Your Ref: OWPC20483
Our Ref: BR/222/18/PL 02-08-2018
Please ask for:
Mr S Davis

Erection of 4no. 2 bedroom dwellings with associated parking & landscape.
Land adjacent to Community Centre Westloats Lane Bognor Regis

Thank you for your internet representation made on 8th November 2018 which has been recorded as '**an objection**' with the comments as follows:

UNITS 1-4 PLANS

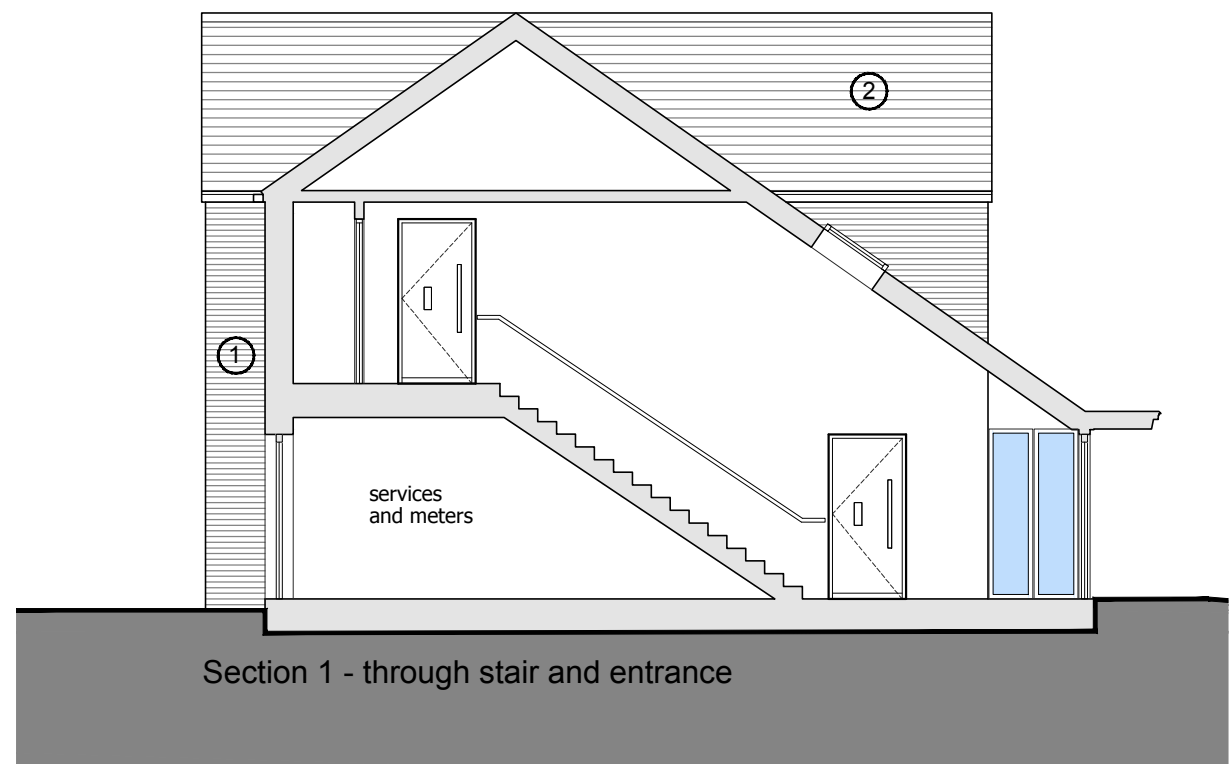
Northern facing secondary 1st floor lounge window should be removed to stop overlooking our garden. We have bought our house because it has got this beautiful garden where we have enjoyed our time in private.

In planning application are gables which I think should be replaced with sloping tiled roof to lessen the impact.
